Your Ref: OWPC19859
Our Ref: EG/49/18/OUT 03-07-2018
Please ask for:
Michael Eastham

Outline application with some matters reserved for the demolition of 1 No. dwelling & erection of 10 No. new dwellings, widening of existing access to provide improved visibility splays, maintaining front boundary buffer of approximately 5m in depth, car parking for 30 cars (including garages and visitor parking) & landscaping.

Bexstone House Barnham Road Eastergate

Thank you for your internet representation made on 1st September 2018 which has been recorded as **'no objection'** with the comments as follows:

RESIDENTIAL DEVELOPMENT CONCEPT SKETCH **SCHEME 'A'**

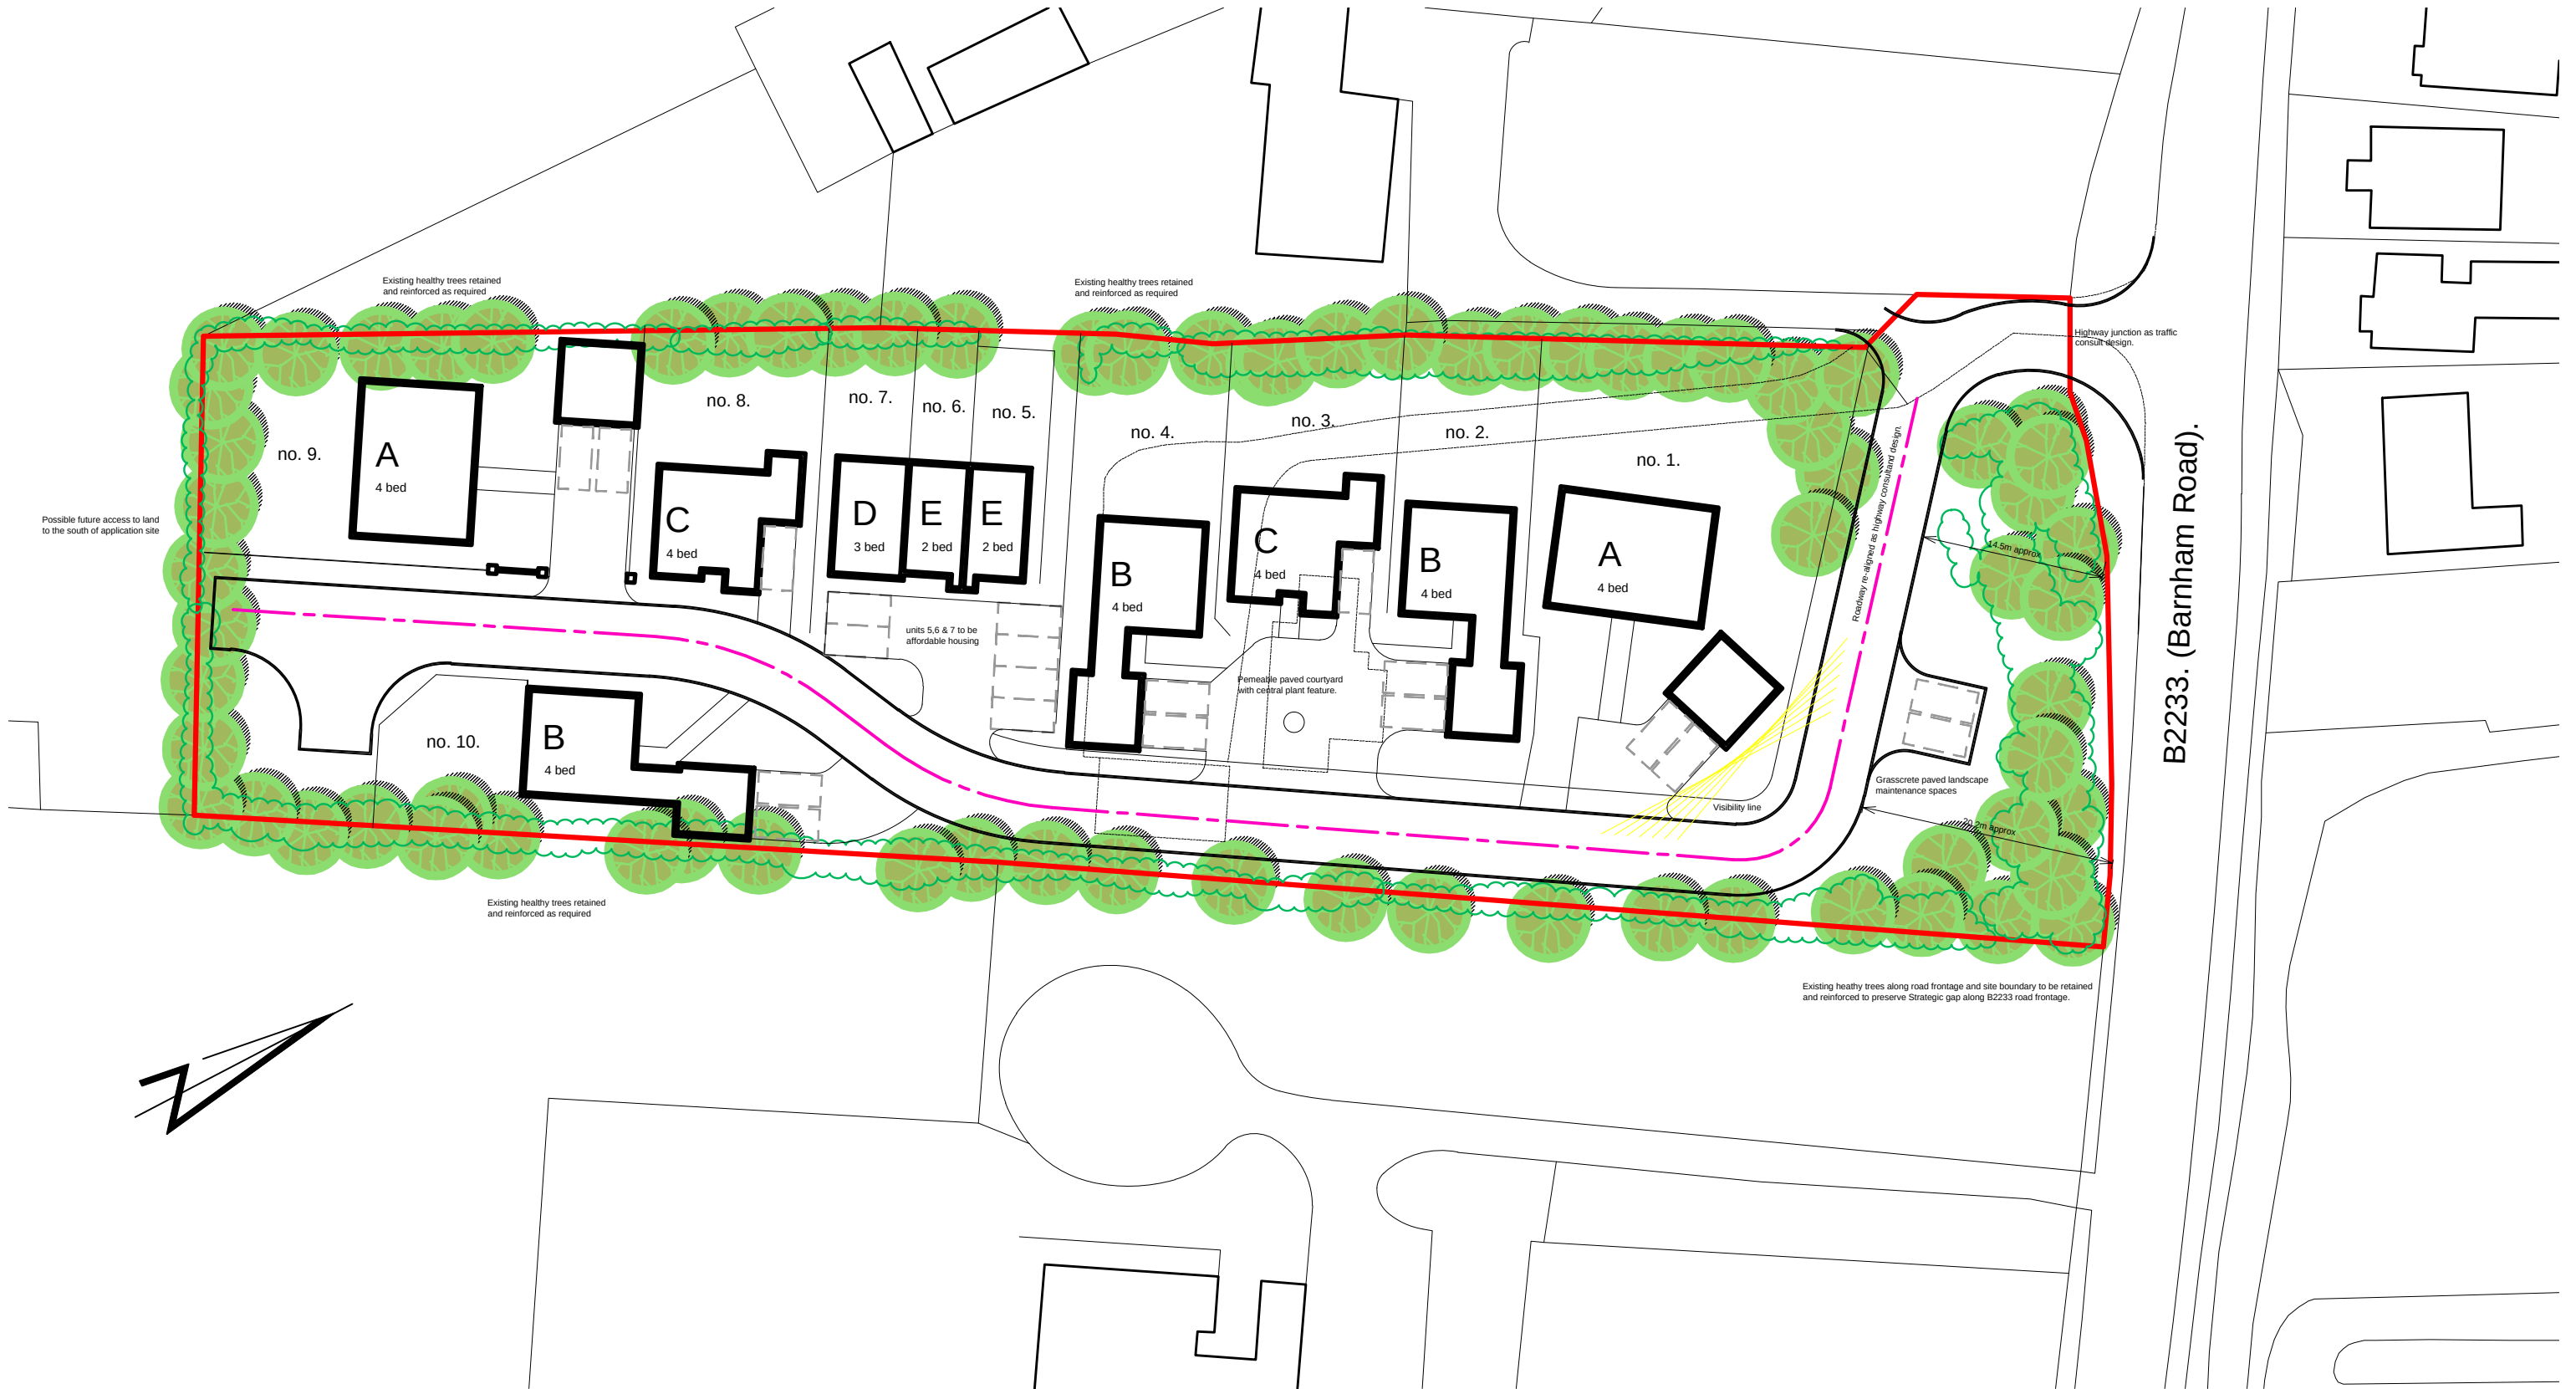
Seven gardens in the proposed development will back directly onto Kinnersley. Bexstone's plan to keep the current mature tree boundary will provide high level screening between the sites. However, the proposed Bexstone plan does not address how the new houses will be bounded at ground level to protect the privacy and security of adjoining properties, Kinnersley and Little Warwick.

Drawing Title
Internal Swept Path Analysis and Concurrent Car Movement

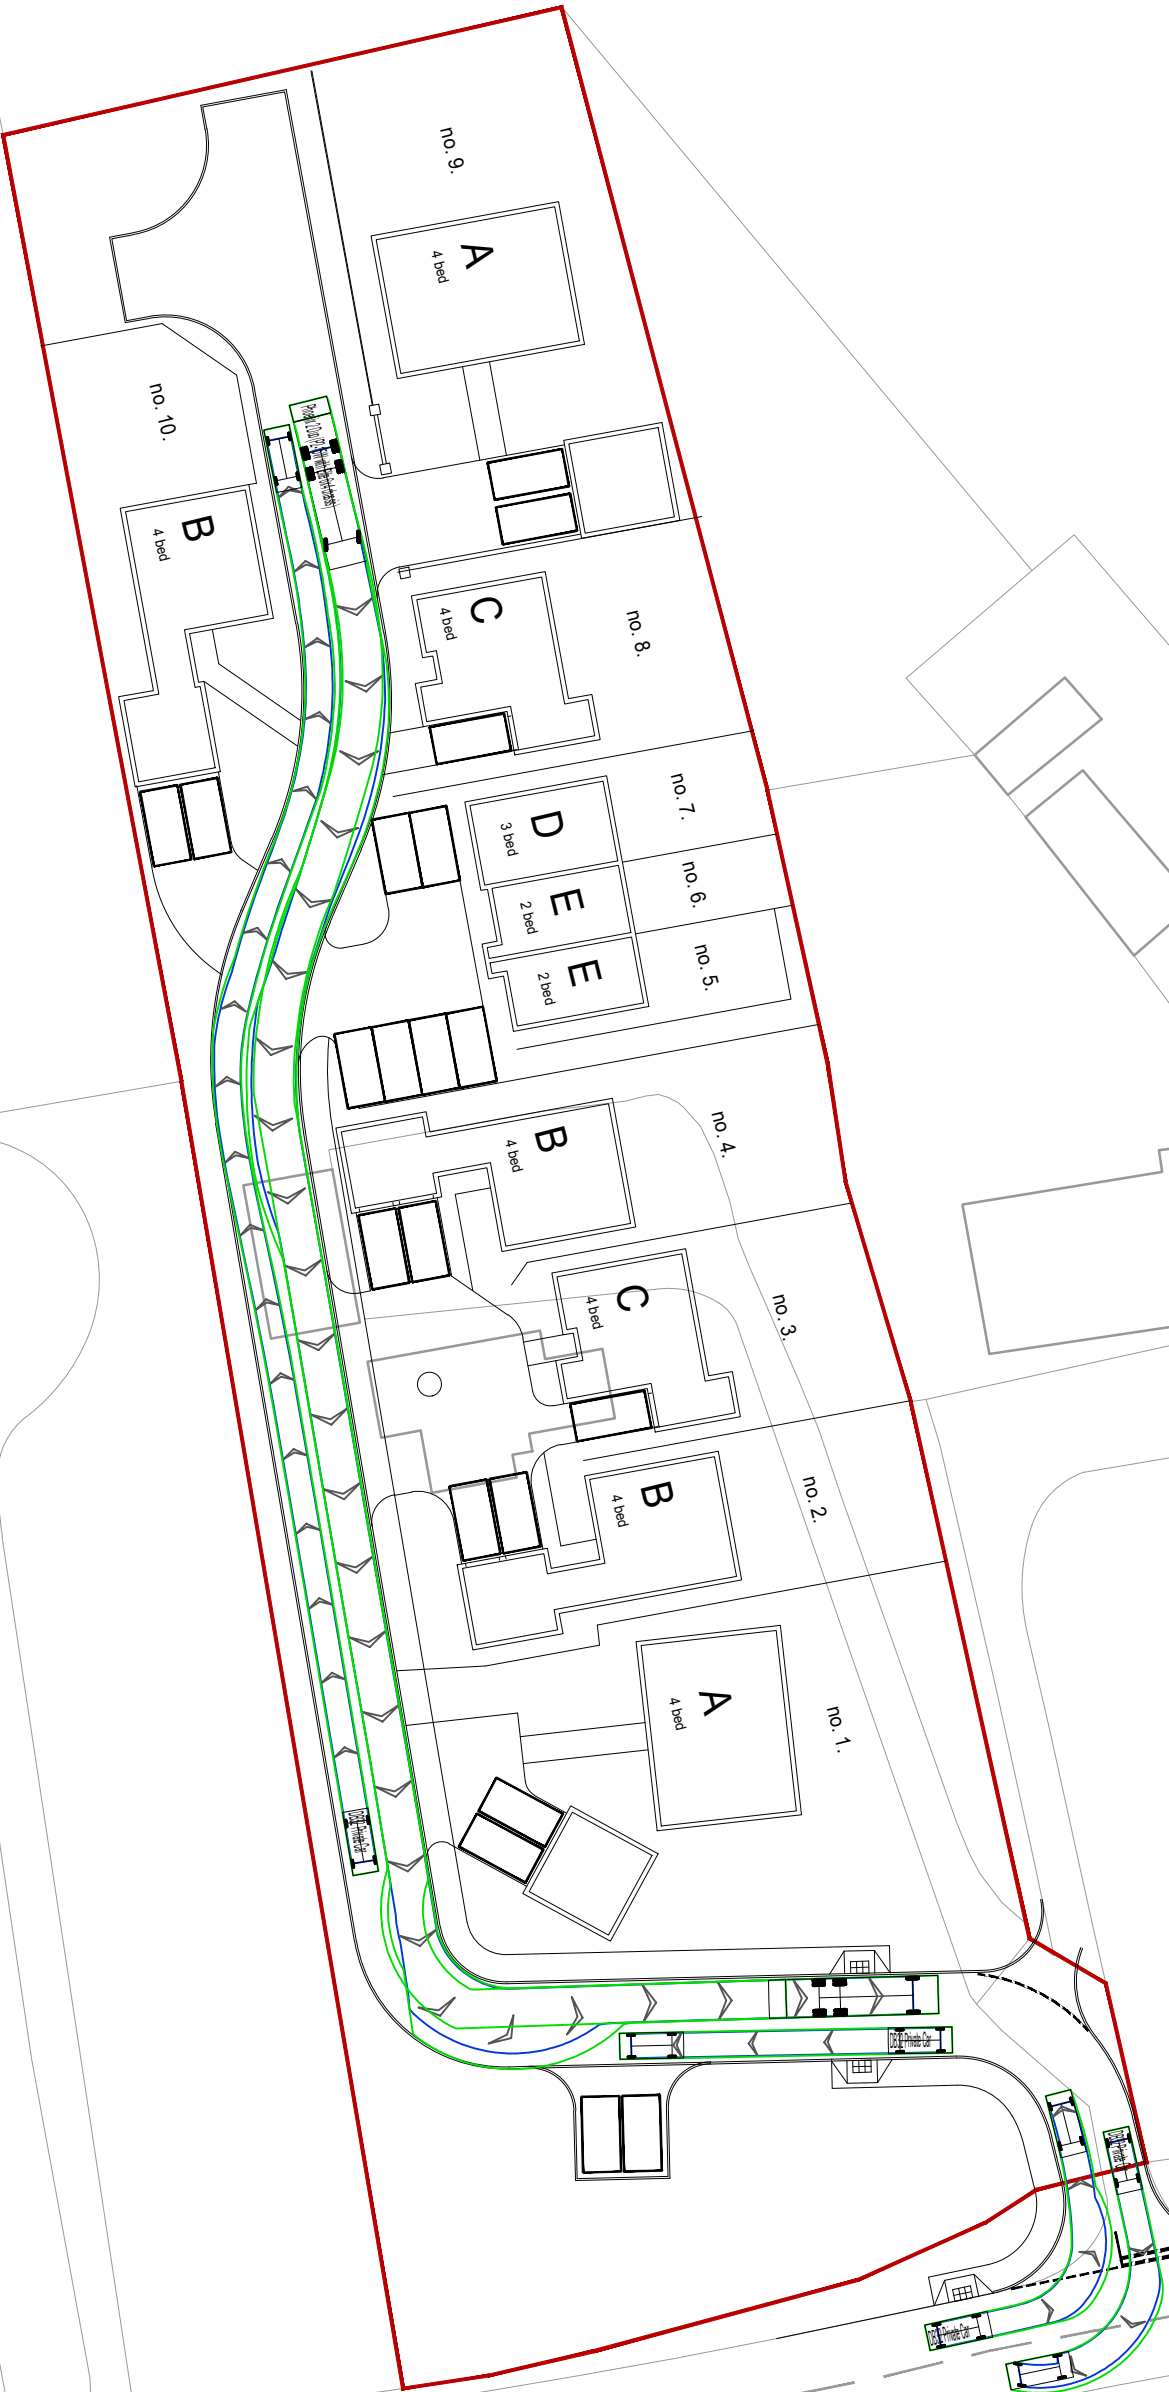
- *Safety and Traffic - Kinnersley has right of access to the B2233 highway over the first section of Bexstone driveway. Kinnersley uses oil fired heating and requires regular oil tanker deliveries to the rear of Kinnersley site. The proposed road changes alter the access angles to Kinnersley drive way making it impossible for the oil tanker to enter Kinnersley drive without driving across the new kerbs and/or Kinnersley lawn and garden. The proposed road layout needs to be revised to permit easy and safe oil tanker access to Kinnersley.*
